Subject: FW: Request for further information LU/84/20/PL

EXISTING REAR
ELEVATION

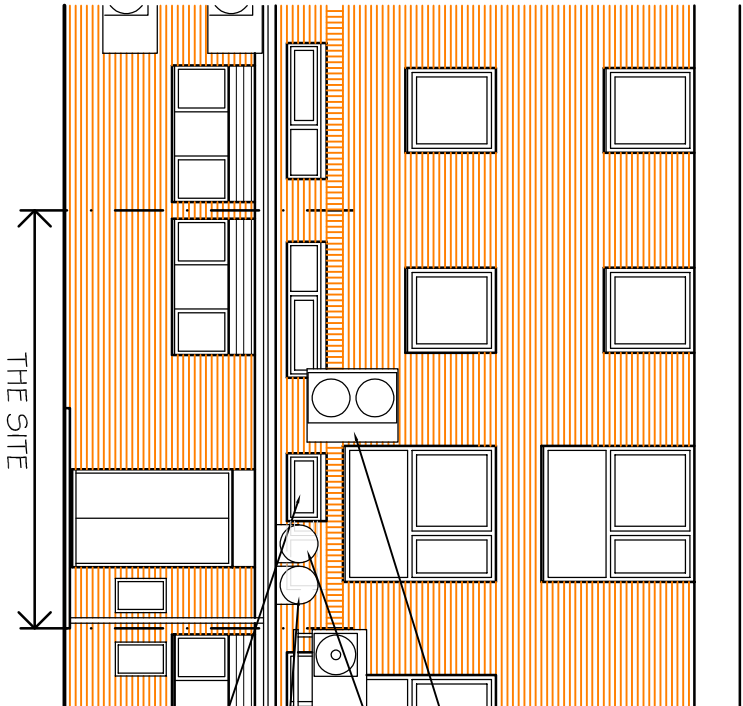
Thank you for your emailed letter dated 31 March 2020. I can confirm that the rear windows have indeed been shown correctly both on the plans and elevations. There are two windows serving the existing WCS, and between these there is a solid panel infill. This is as shown on the attached photograph.
